Application No: K/20/20/NMA
Site Address: Flint Barn Peak Lane Kingston BN16 1RN
Description of works: Non-material amendment following grant of reference K/6/20/HH for a new balcony to first floor master bedroom and loft space, align windows and new window styles (now full height), amended internal layout to study/bathroom area and new window from dormer to the west.

Thank you for your internet representation made on 15th July 2020 which has been recorded as an objection with the comments as follows:

04 PROPOSED SOUTH ELEVATION
Scale: 1:50

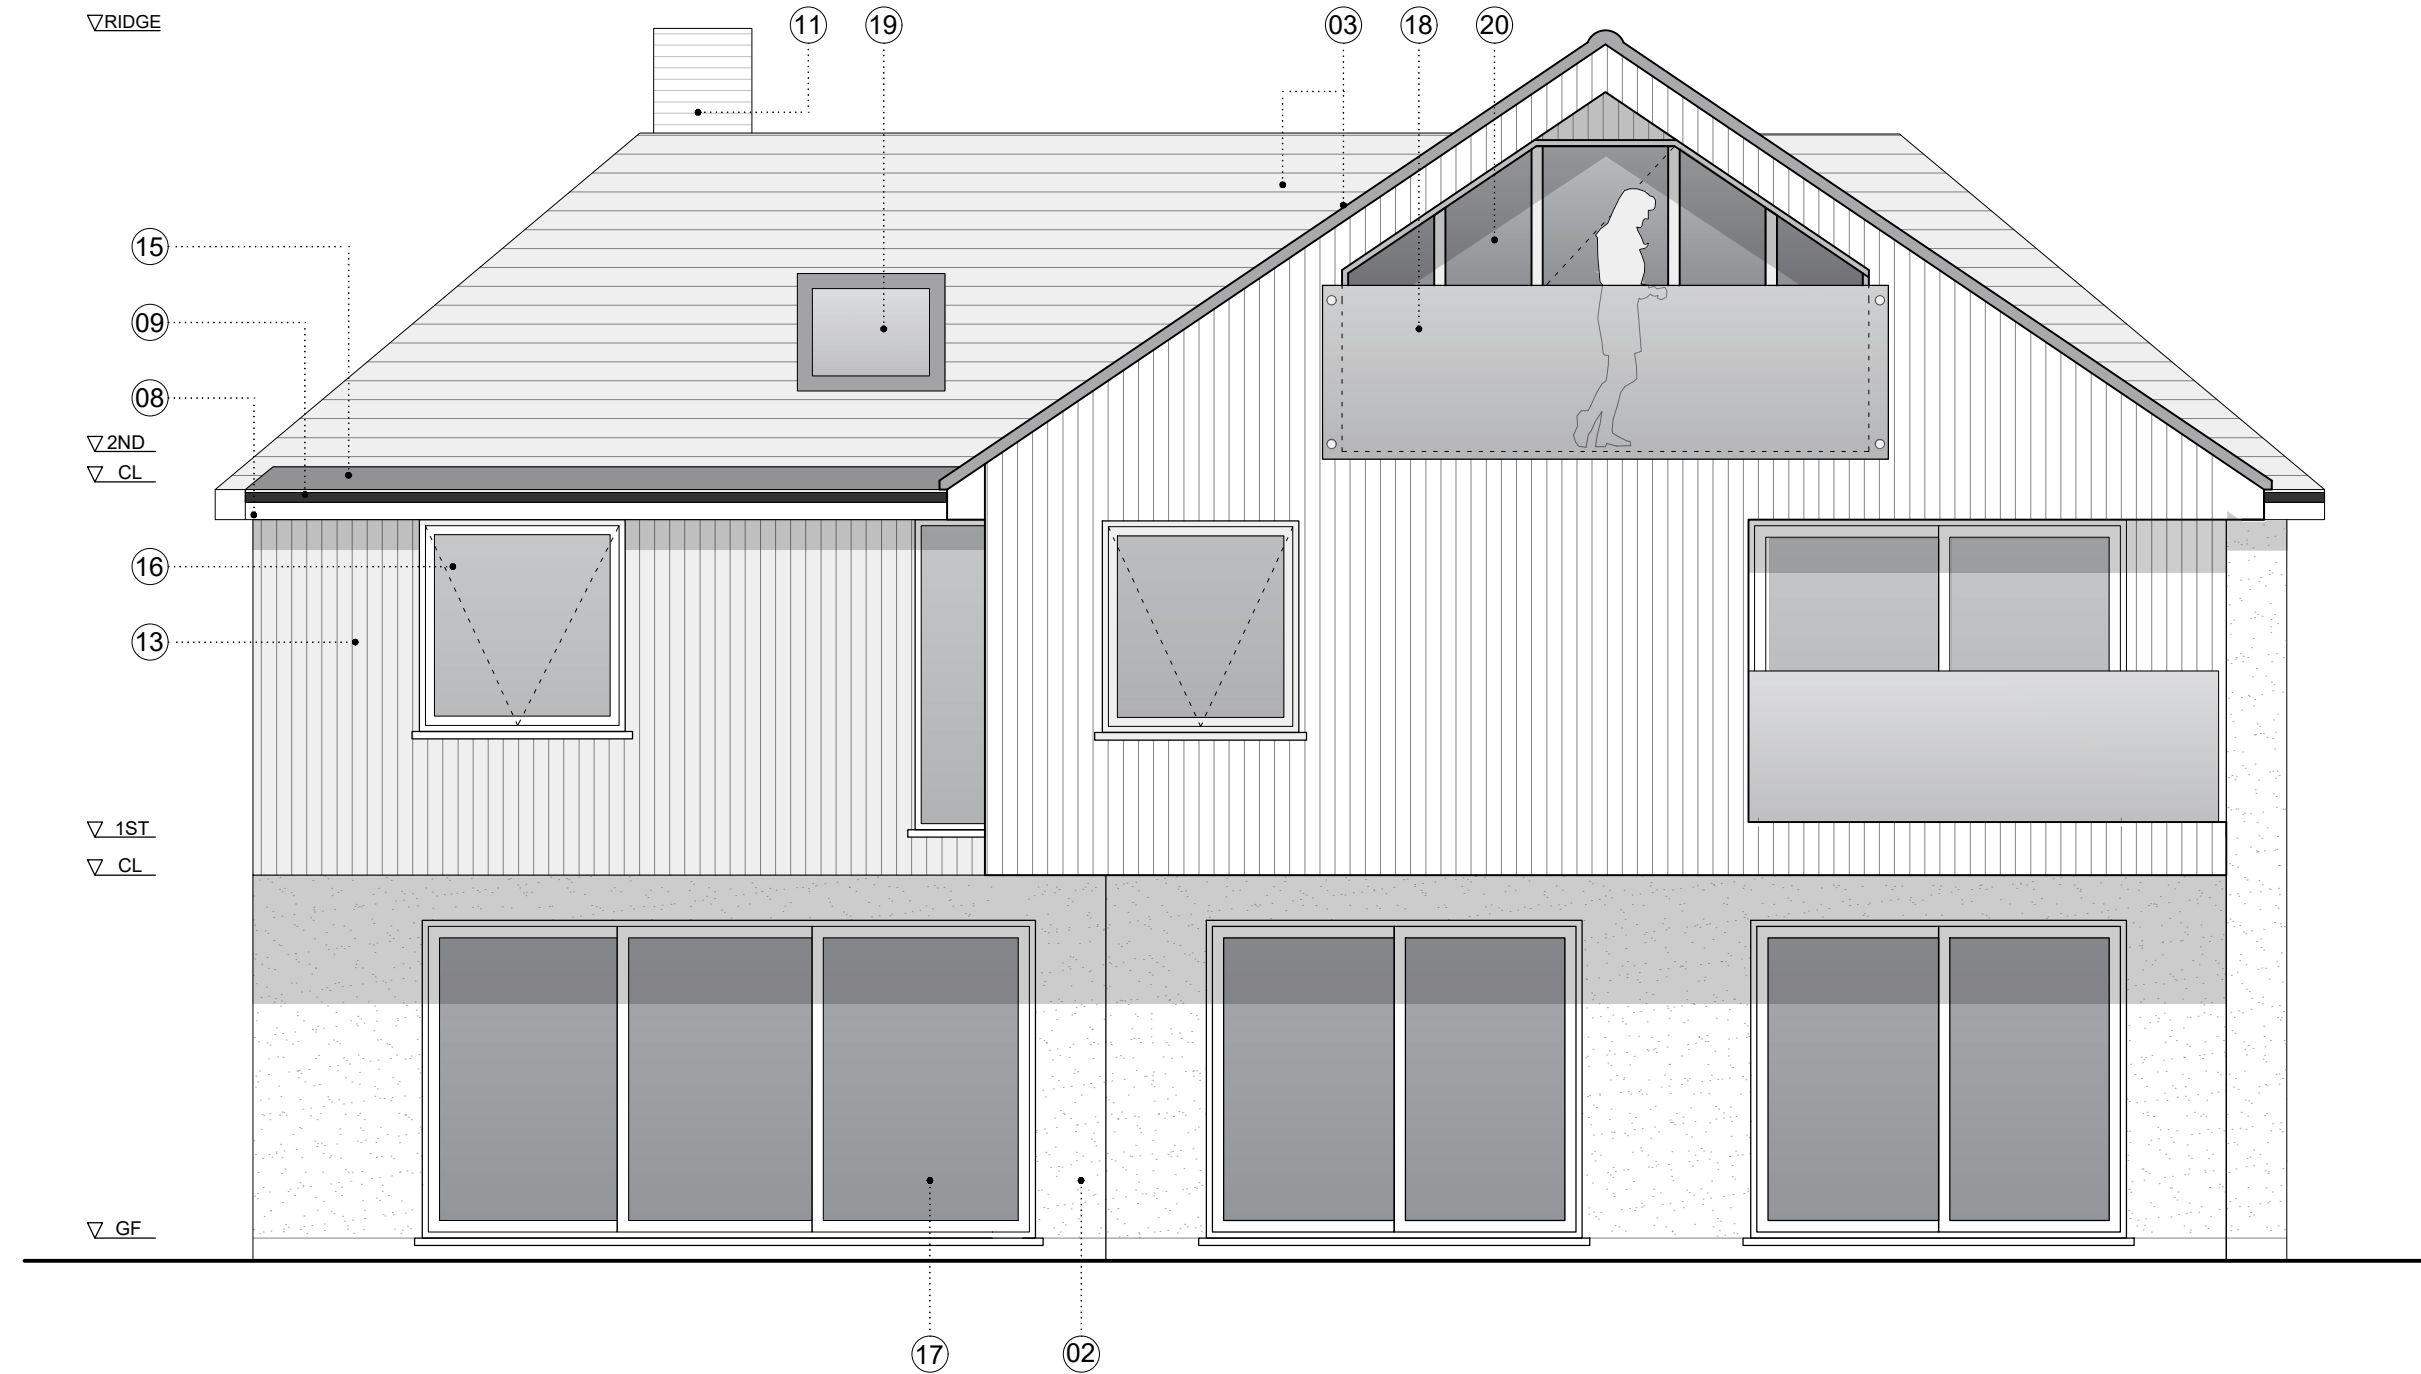
What a "hot house pot" of a design from all angles! The south-facing elevation which overlooks my back garden, has an added floor and balcony which is totally out of keeping with a converted barn in a rural setting. The roof line has also increased. The foot print of south elevation has also increased which bring the property much closer to the boundary.

Drawing  
Existing & Proposed Site Plan

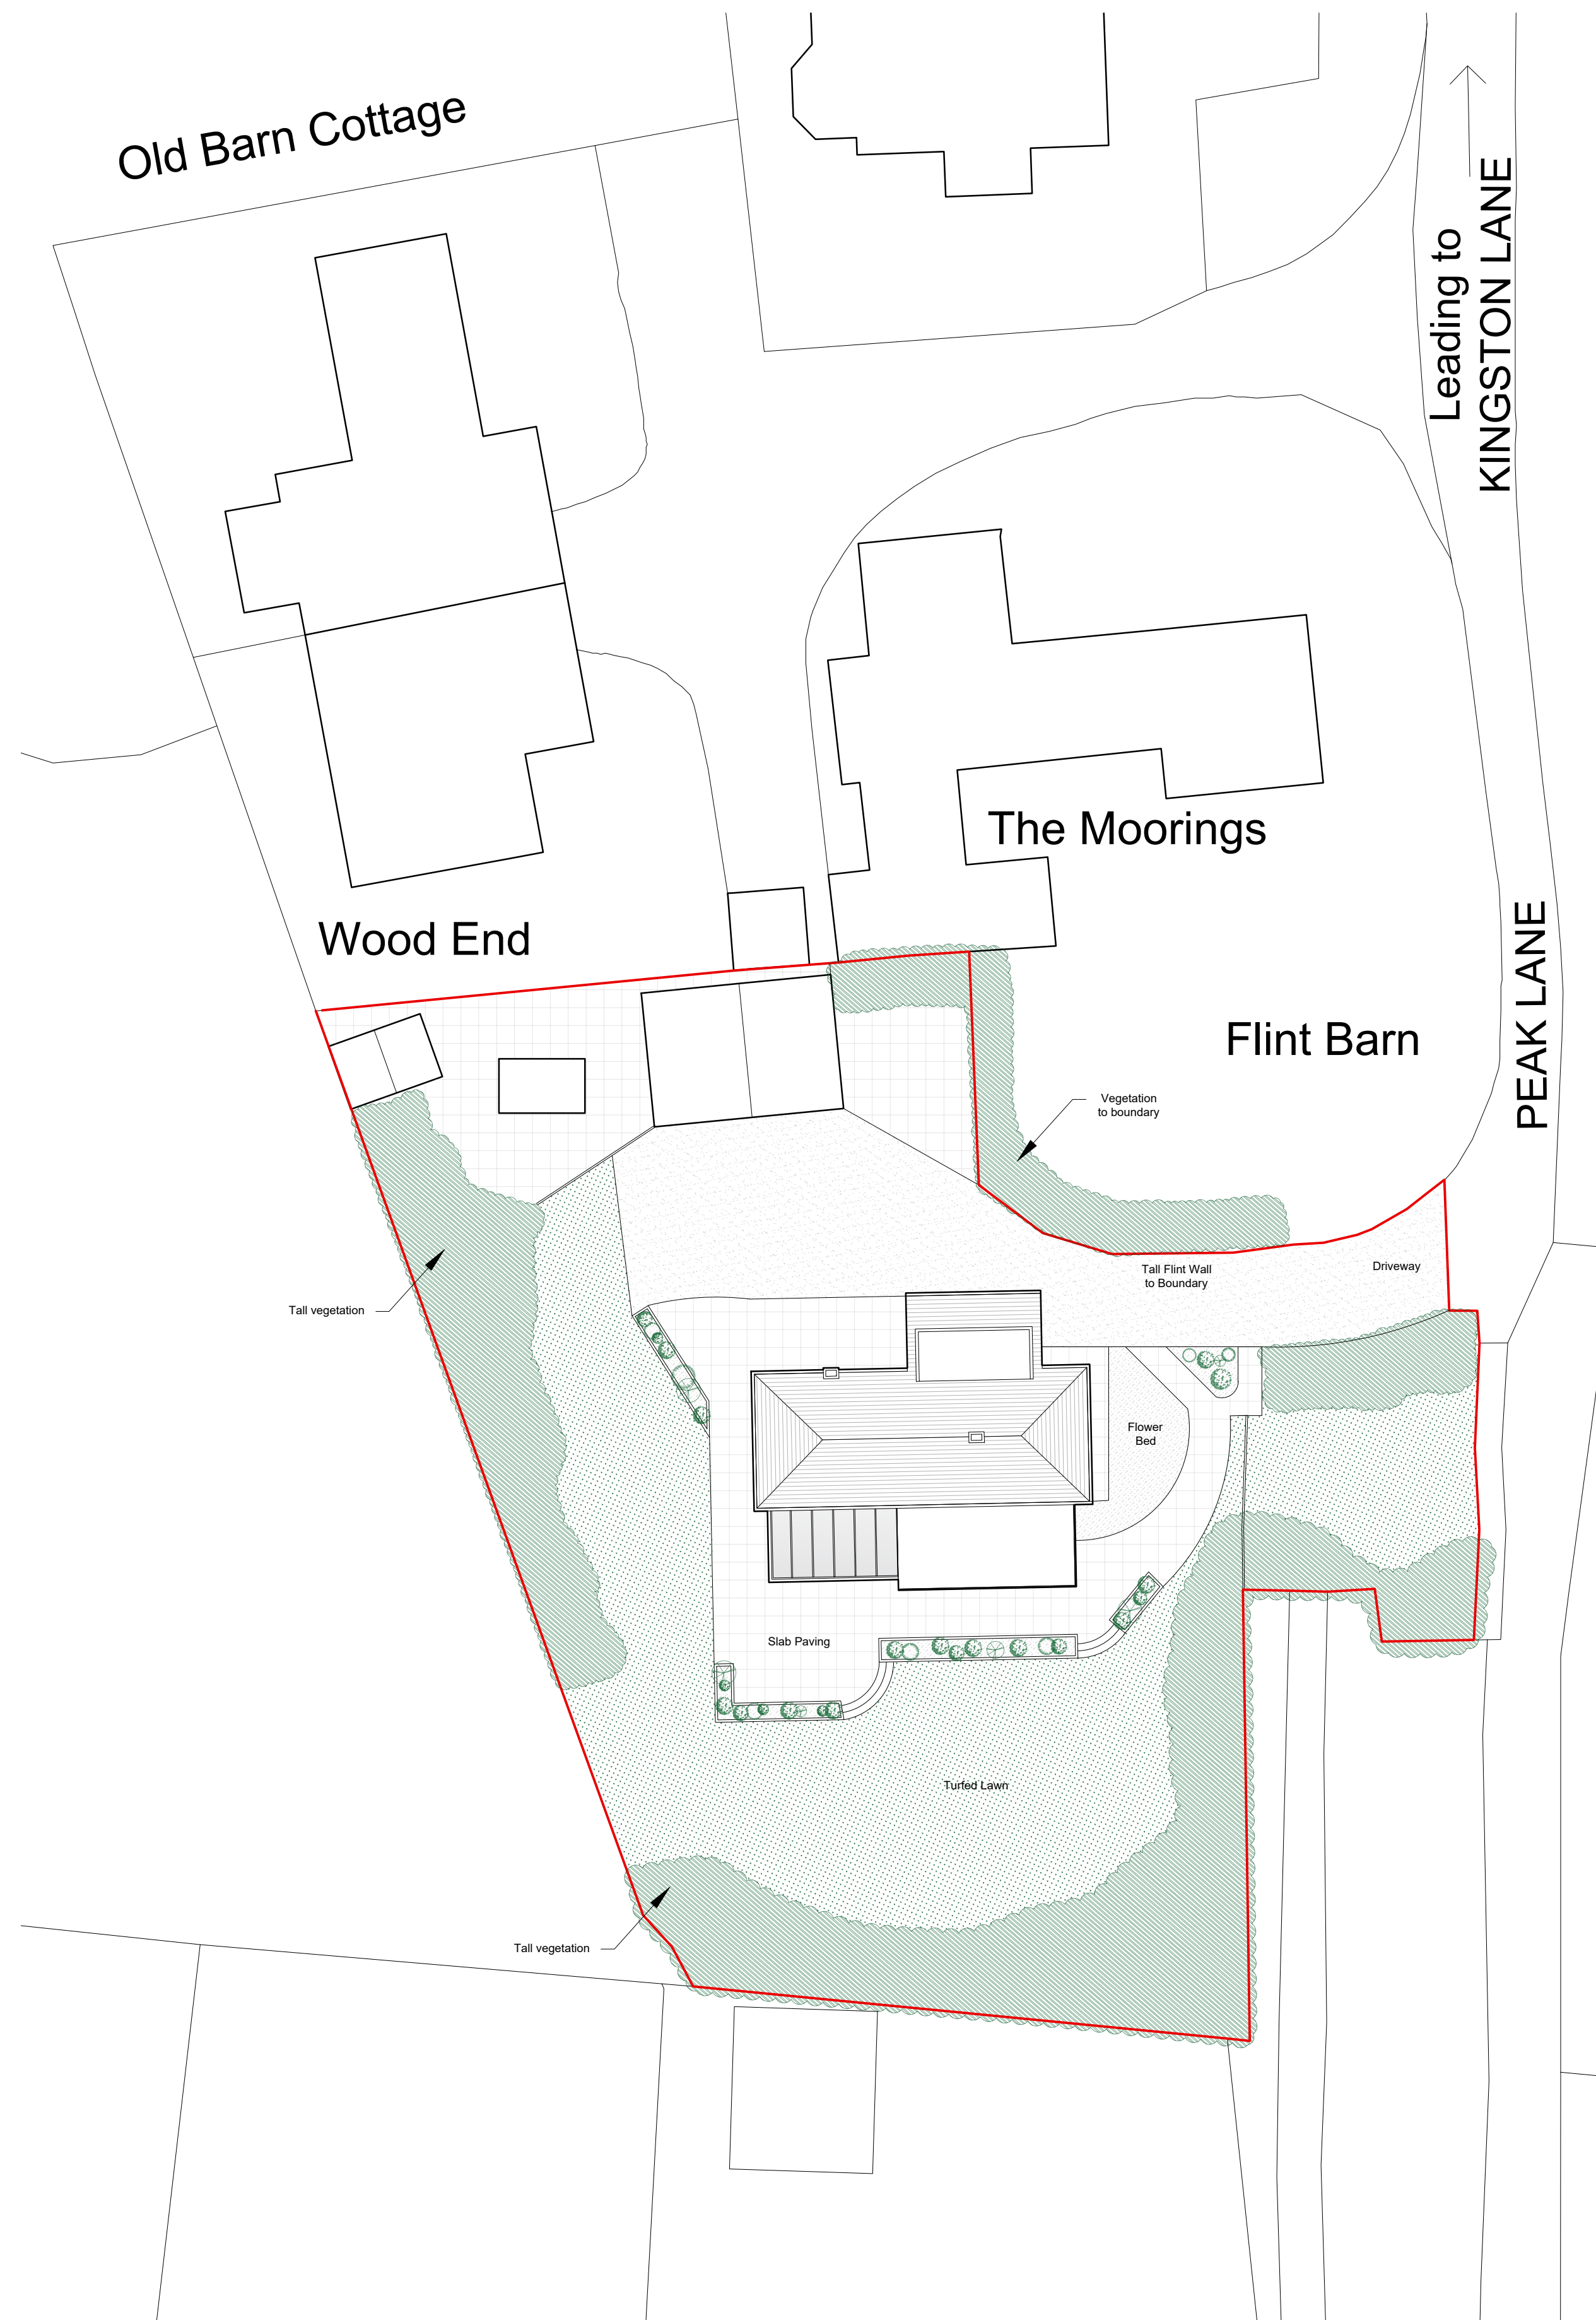
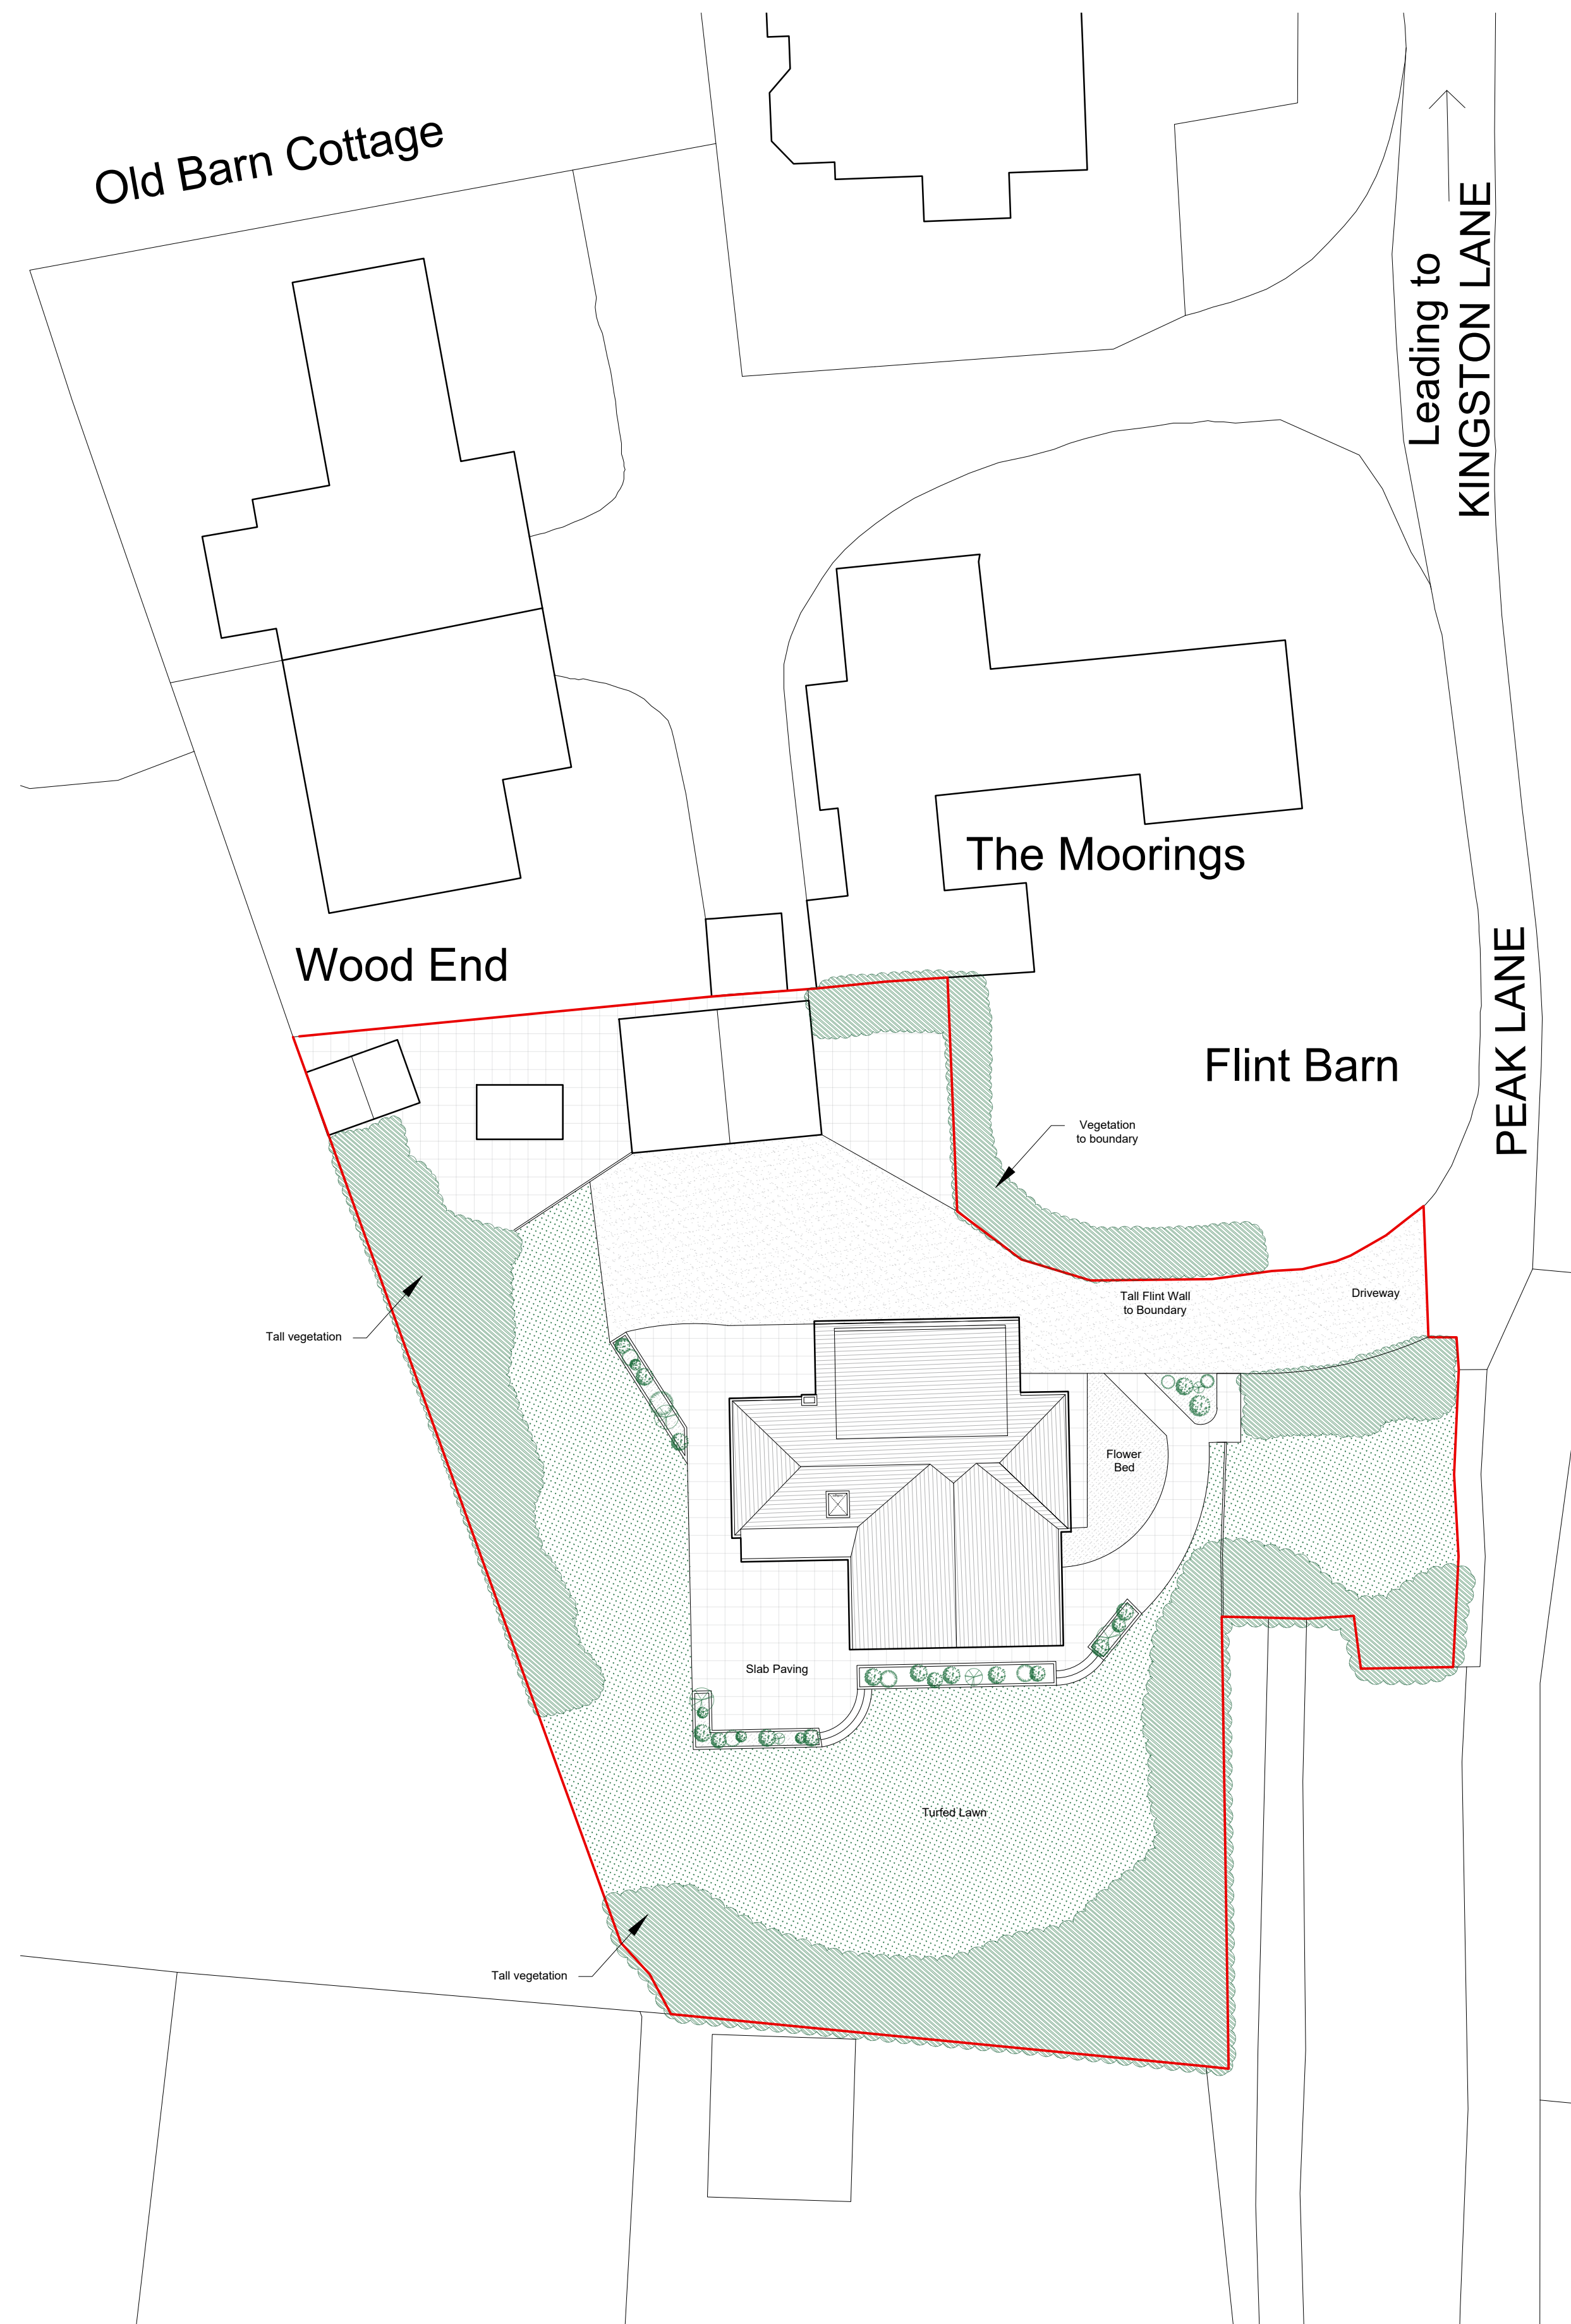
Also the applicant has suggested his boundary to Peak Lane on the plan is much greater than it is. Peak Lane is a public ByWay and therefore his land is smaller between his property and Peak Lane.
